45-53 Macleay Street Potts Point

Response to Submissions

This Submissions Report has been prepared by Urbis on behalf of Time & Place Pty Ltd (**the Applicant**) to address the matters raised during the public exhibition of the State Significant Development Application (**SSDA**) for the redevelopment of 45-53 Macleay Street, Potts Point (SSD-79316759).

12 SOLAR ACCESS - L1  
1:300

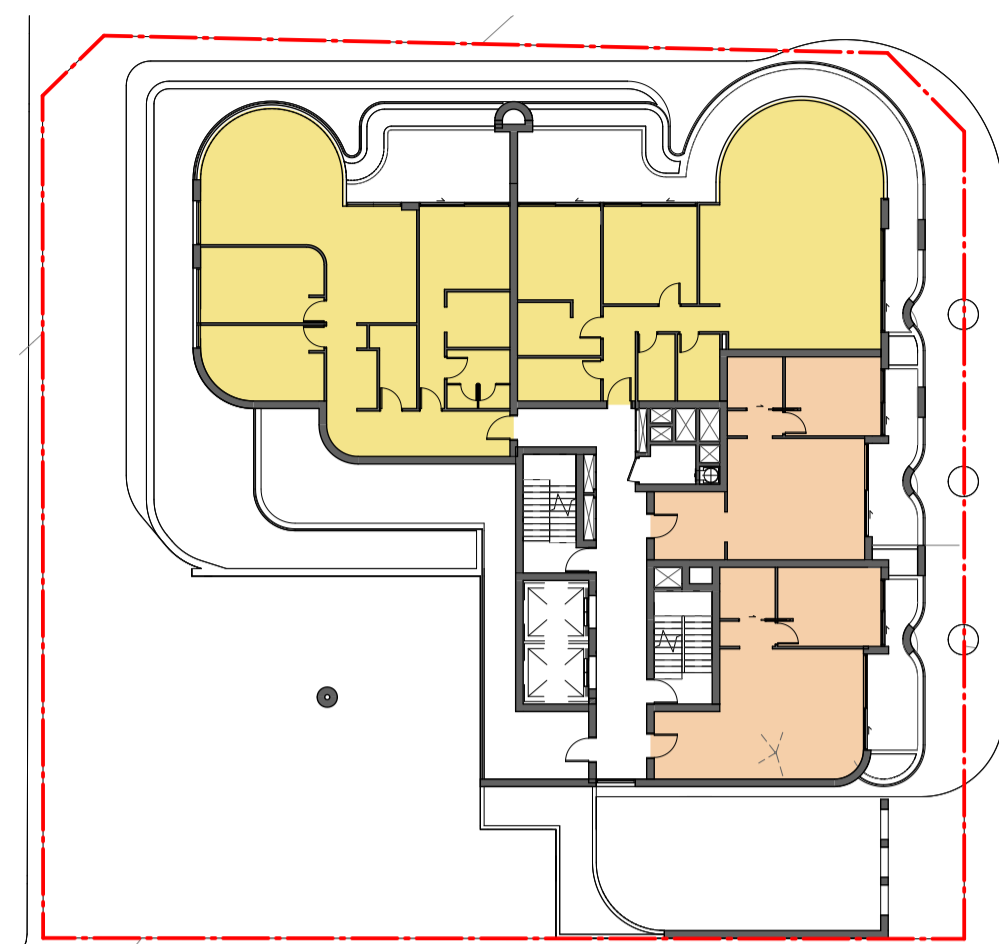
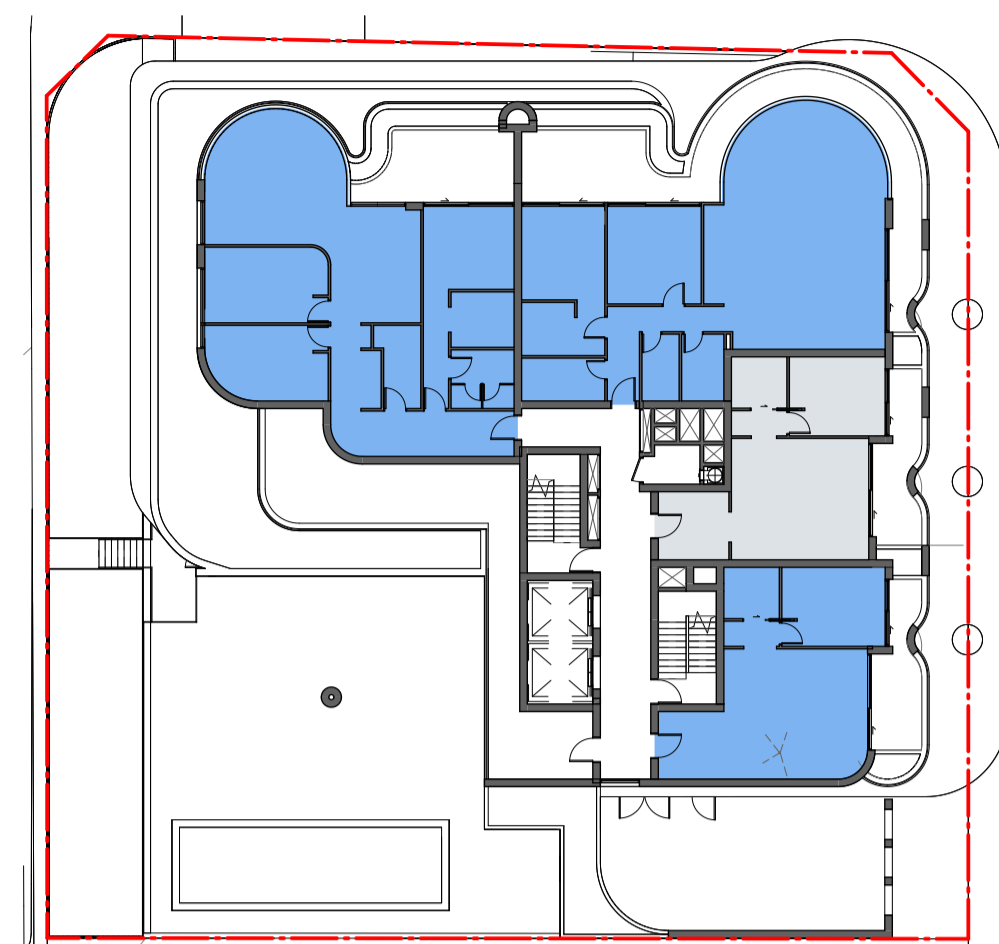
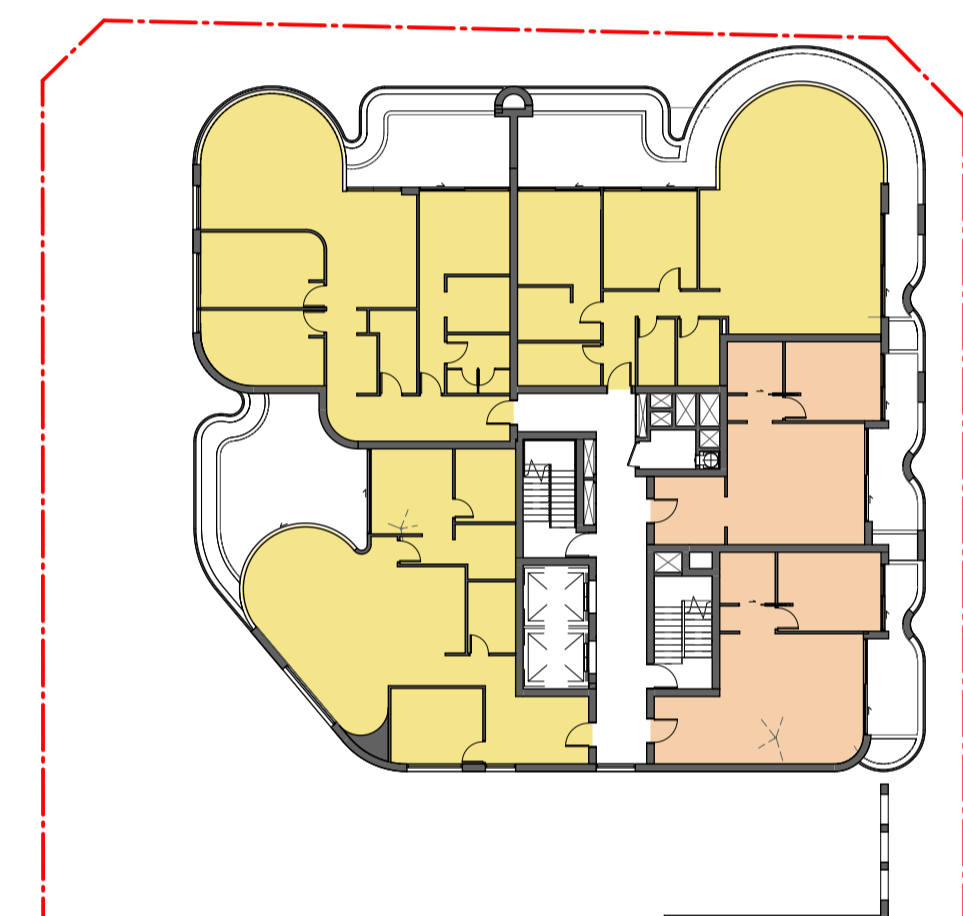
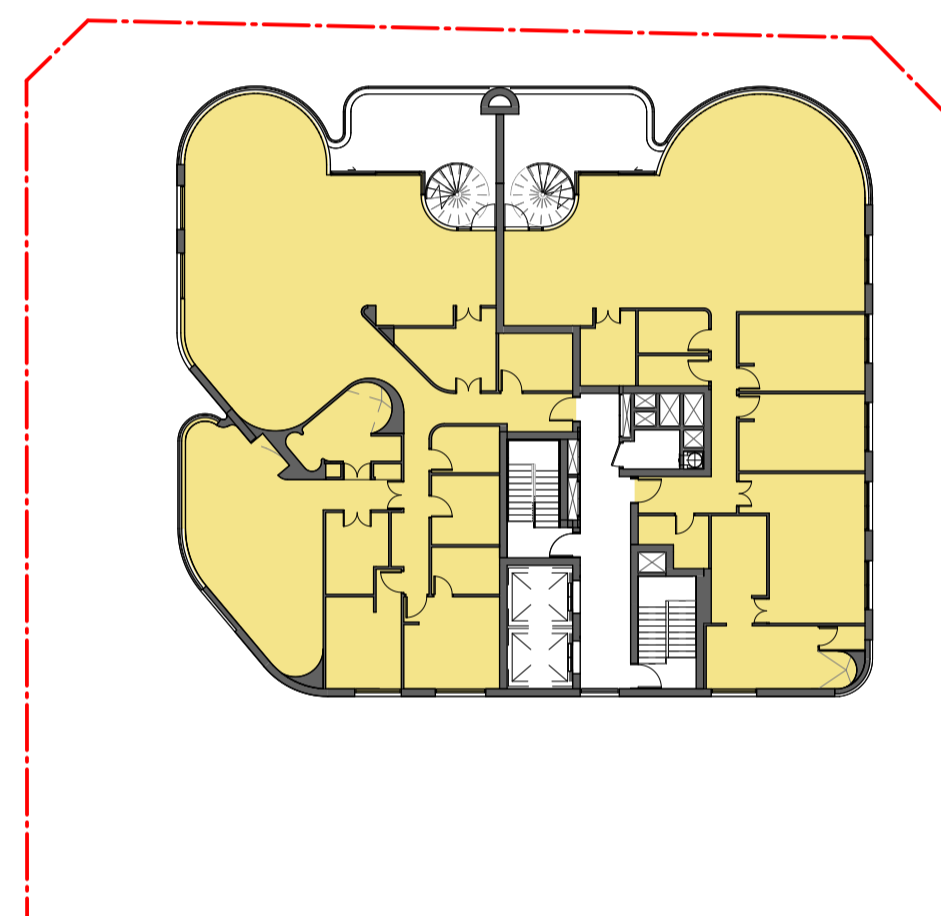
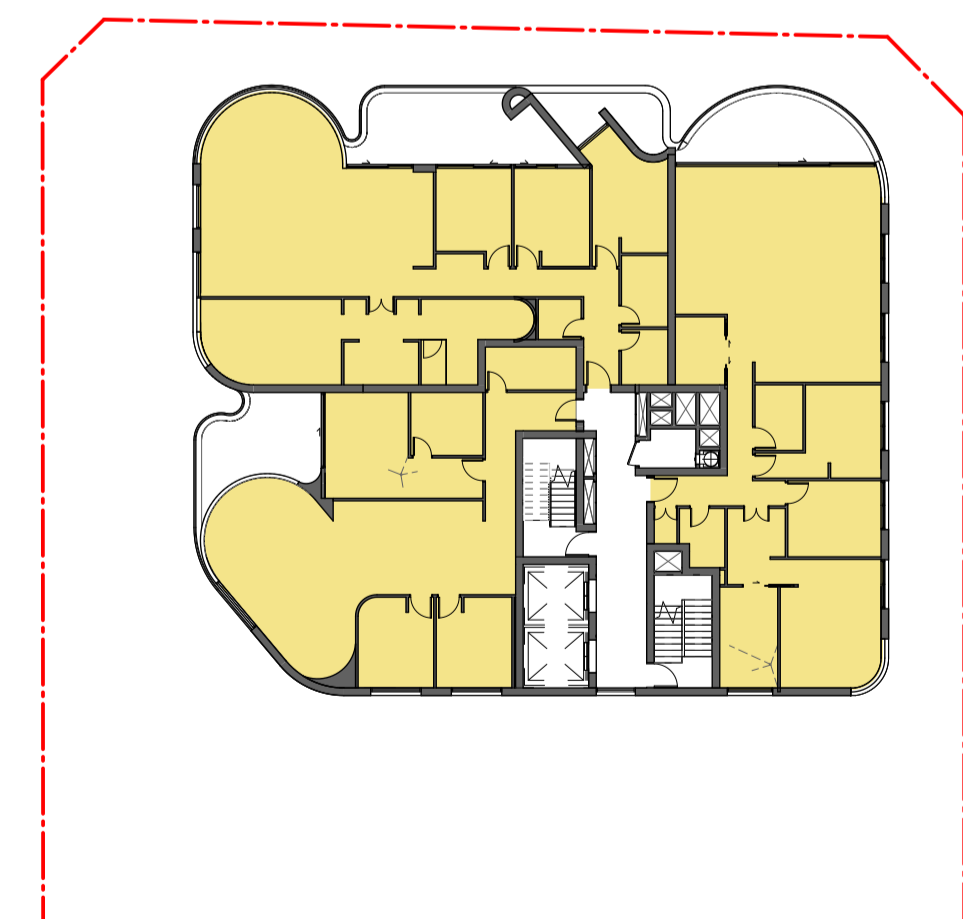
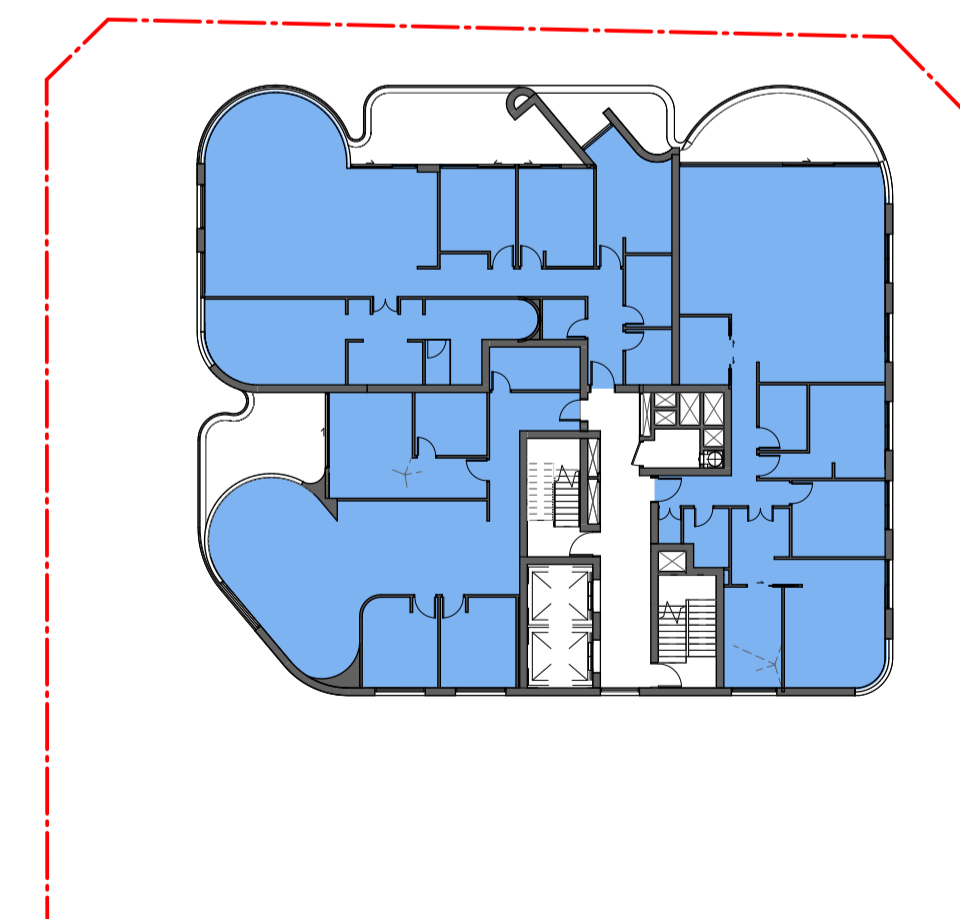
Reference scheme		
<ul style="list-style-type: none"> ▪ Update the reference scheme plans to: <ul style="list-style-type: none"> – illustrate and quantify the apartments that would achieve at least two hours of solar access on 21 June – illustrate and quantify the apartments (below level 9) that would achieve natural cross ventilation. 	<p>Updated reference scheme plans have been provided by SJB at Appendix C.</p> <p>The Updated Reference Scheme Plans demonstrate that 30 apartments, or 88.3% of apartments, would achieve at least two hours of solar access during mid winter and 32 apartments, or 94.1%, would achieve natural cross ventilation.</p>	Appendix C
Additional information		
<ul style="list-style-type: none"> ▪ Provide an updated survey plan that reflects the levels across the site, including contours and levels within the existing building footprint, to enable building height to be accurately assessed. 	<p>The survey provided at Appendix I of the EIS demonstrates existing ground levels to sufficiently establish the maximum building height.</p>	Appendix I
